Application by NNB Generation Company (SZC) Limited for an Order Granting Development Consent for The Sizewell C Project

The Examining Authority's written questions and requests for information (ExQ1)

Issued on 21 April 2021

Plate 7.2: Sizewell C Spent fuel management strategy.

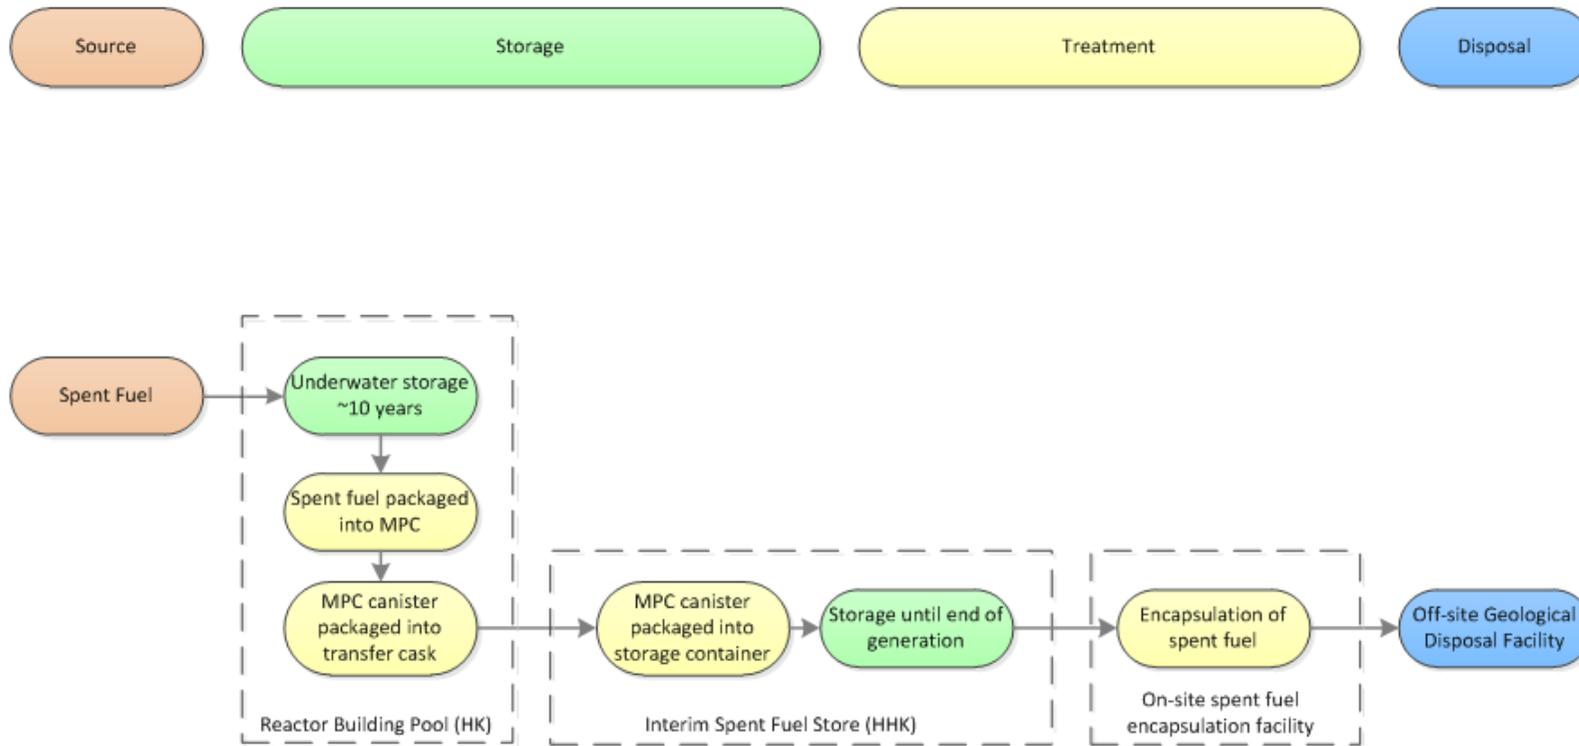
R.1.7	The Applicant	Spent Fuel There appears to be an error in the calculation at para 7.7.73. [APP-192] 60 years divided by 18 months = 40 planned outages. 90 spent fuel assemblies are proposed to be removed on each occasion from each reactor. $90 \times 40 = 3,600$ not 3,400 as set out. (i) Has the paragraph correctly set out the estimated number of assemblies to be removed? If so please explain how this has been calculated. (ii) In the event there is an error: a) Please explain whether the interim store as designed for 7378 assemblies has sufficient capacity + contingency + the additional 16 years of operation referred to previously; b) if not, how will the additional capacity be catered for? c) If an increase is necessary, can this be accommodated within the building parameters as shown? Explain whether the correct figures have been used in undertaking the ES?

ExQ1	Question to:	Question:
R.1.8	The Applicant	Spent Fuel Para 7.7.74 [APP-192] does not appear to include the likely additional number of spent fuel assemblies you have assessed as a contingency. In addition, neither calculation includes the possible extension of the life of the plant for a further 16 years as referenced in other documents within the ES (para 22.6.244 of APP-317). In considering your response please take account of your answer to R.1.4 above to fully explain the capacity required for storage and the total inventory you would expect at the end of generation.
R.1.9	The Applicant	Spent Fuel Does any of the above have any knock on effects to the other calculations made within the documentation? If so please explain what effects this would have and whether this has been addressed within the ES.
R.1.10	The Applicant, ONR	Spent Fuel (i) Please confirm that the current proposal does not include the encapsulation facility referred to at para 7.7.95. (ii) Assuming this to be correct, are you able at this stage to confirm there would be sufficient space within the DCO site to accommodate such a facility? (iii) Do the ONR agree that there would be sufficient space?
